Development Facilitation Team (DFT) – Review Comments

Project No: PR-2024-009956 Date: 3/19/2025 Agenda Item: #5 Zone Atlas Page: M-9

Request: Proposed site improvements for a new tenant building with a Taco Bell quick-service restaurant with accessory drive-thru on the Endcap.

Application For: SI-2024-01475 – SITE PLAN DFT

NOTE:
SEE LANDSCAPE DRAWINGS
FOR LANDSCAPE SCREENING

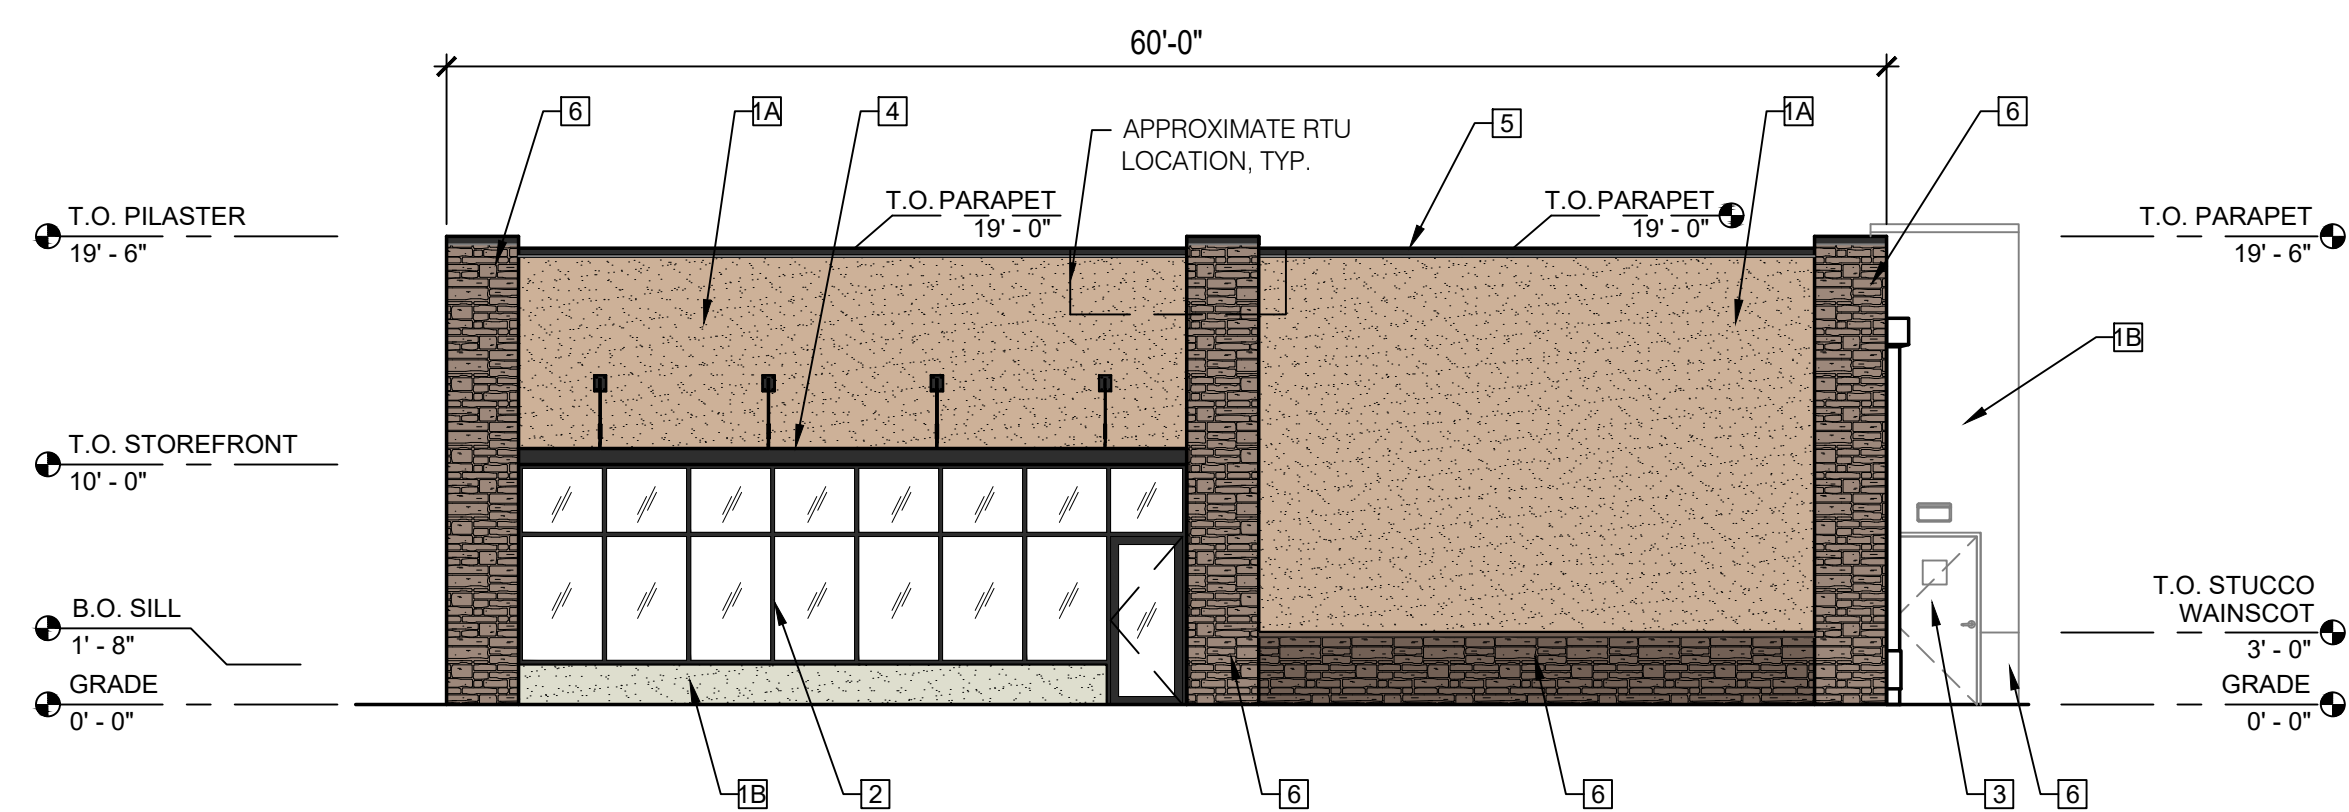
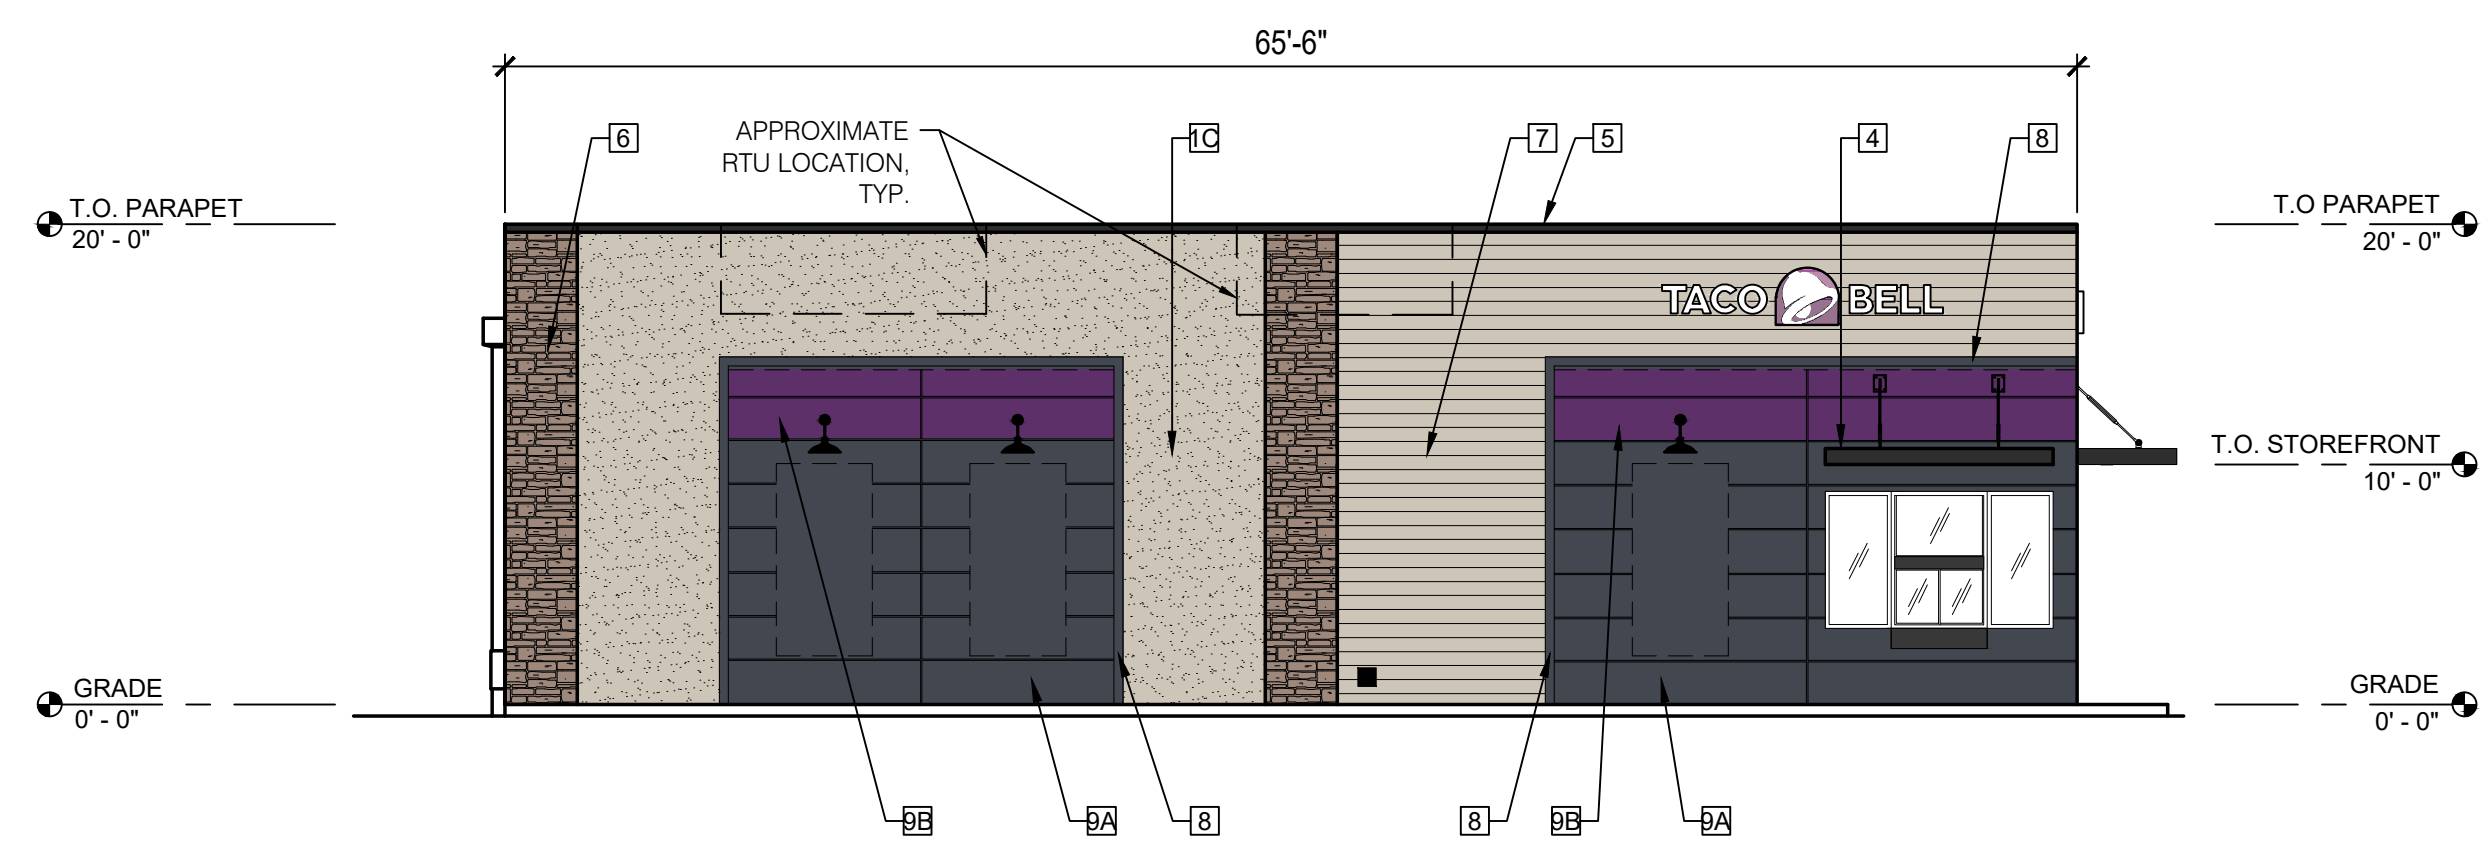
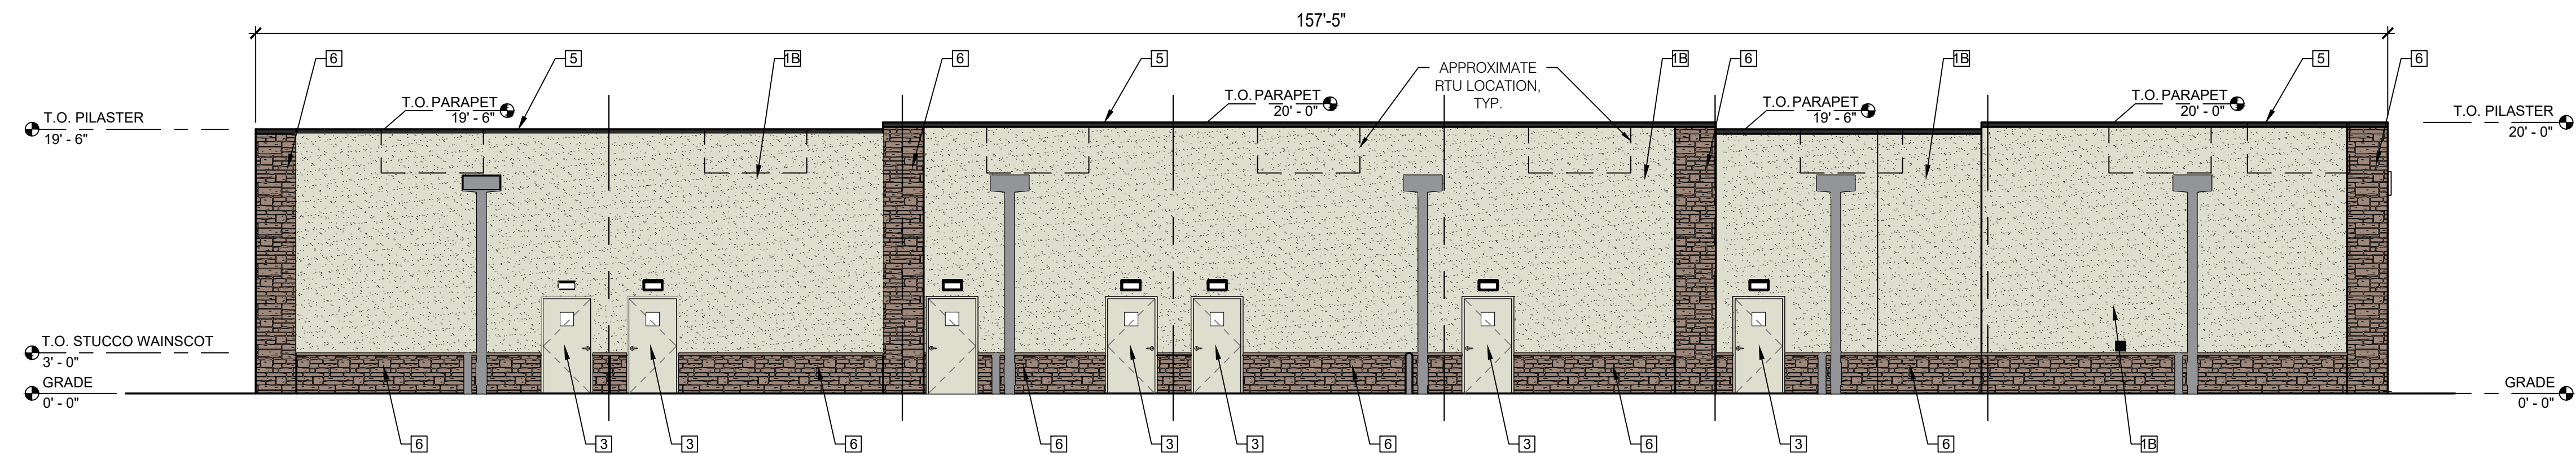
- Additional detail is needed on elevation page or landscaping plan to demonstrate how the entire Drive-Through area meets the Use Specific Standards and screening requirements per **IDO section 4-3-F-5 & 5-5-I**.

Include screening from trail and diversion channel per 5-2-I

We have worked with the reviewer and have provided landscape screening to maximum extent within the constraints of adjacent easements.

SITE PLAN  
SHEET NO.

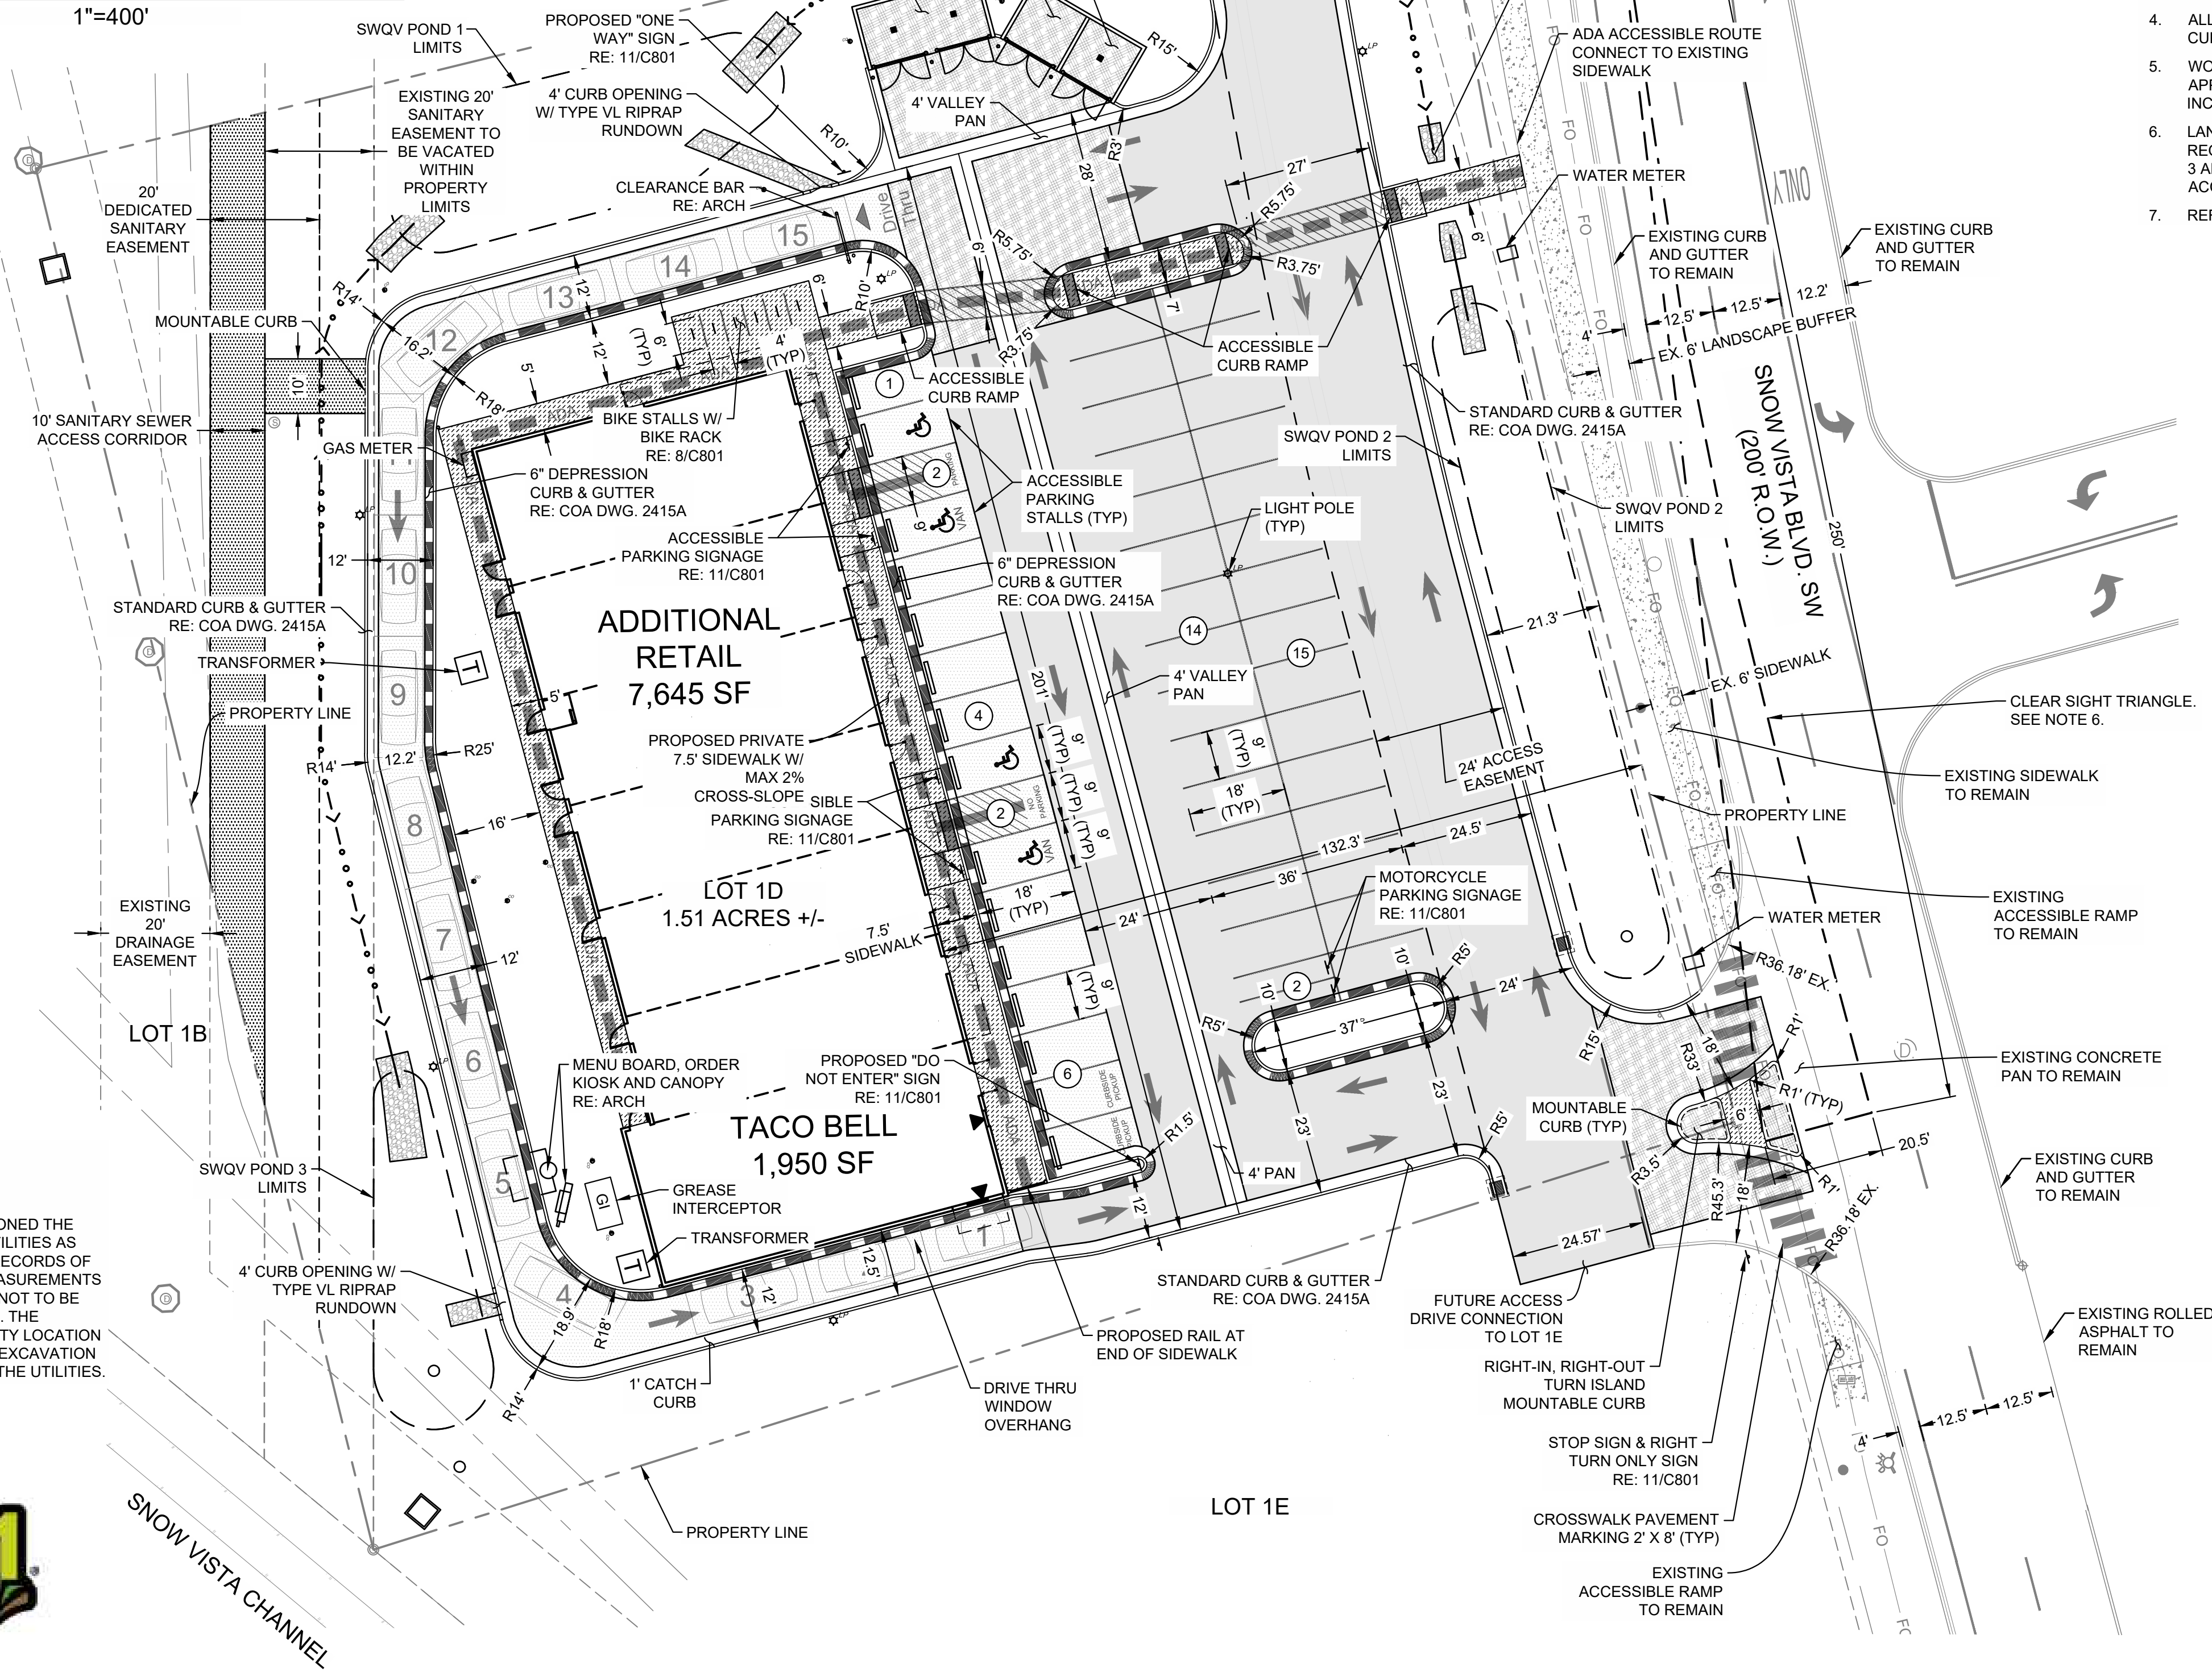
- *Please include a copy of the plat to ensure that there are cross lot access easements in place.*
- *Please show existing sidewalk and buffer along Snow Vista as this roadway is a Principal Arterial and requires 6' sidewalk with a 5' to 6' landscape buffer.*
- *Transportation has an approved TCL dated 6/18/2024, but the Traffic Scoping Form was not signed off prior to this. If a Traffic Study is required then the TCL may need to be modified to meet TIS recommendations. Transportation cannot sign off on site plan until then and the building permit will have a hold placed on it as there may be infrastructure items required.*

A right-in and right-out island has been added at the entrance to encourage those traffic movements.
